HINCKLEY RAIL FREIGHT TERMINAL

Response to Secretary of State's Interim Decision and Tritax Responses

CPRE Leicestershire: Unique Reference: 20038675

February 2025

Figure 2 - Junction 2 New Lining Arrangements

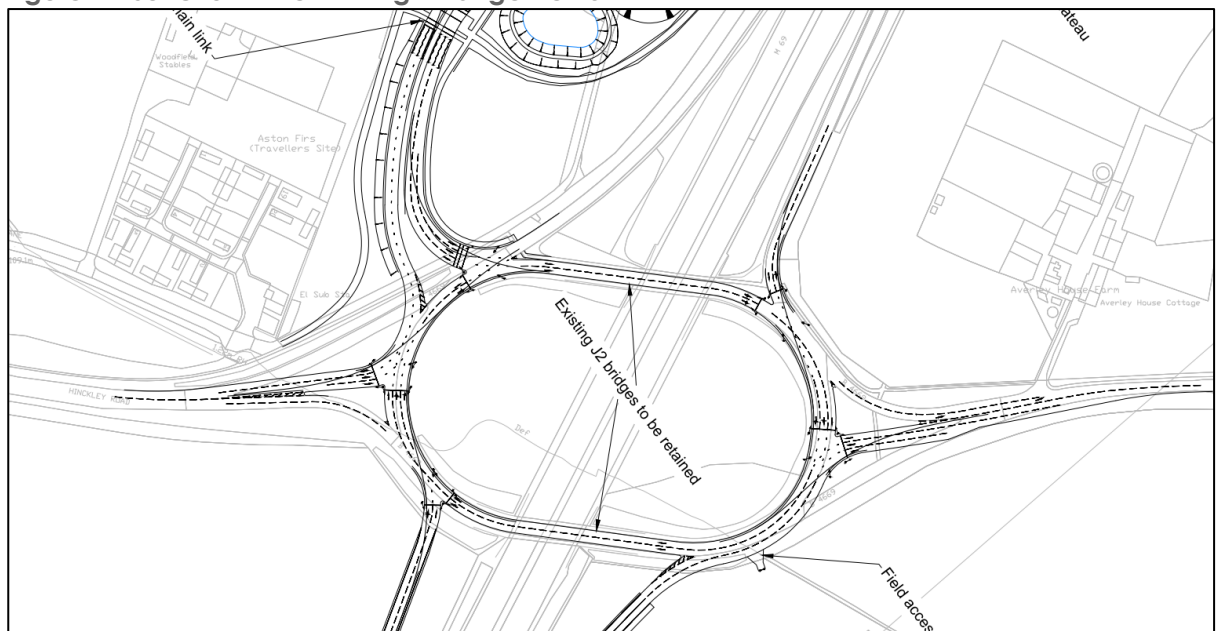
2.0.1 The problems identified at Sapcote have not been resolved. There is a fundamental issue with the addition of south facing slip roads at M69 J2 which would open up a route through Sapcote from the M69 to a large area around the south of Leicester.

2.1.1 The reason for new and displaced HGVs to route through the village has not changed since the Examination. As stated above the provision of the two additional motorway slip roads at Jn2 of the M69 opens up a new route through Sapcote from the M69 to a large area south of Leicester.
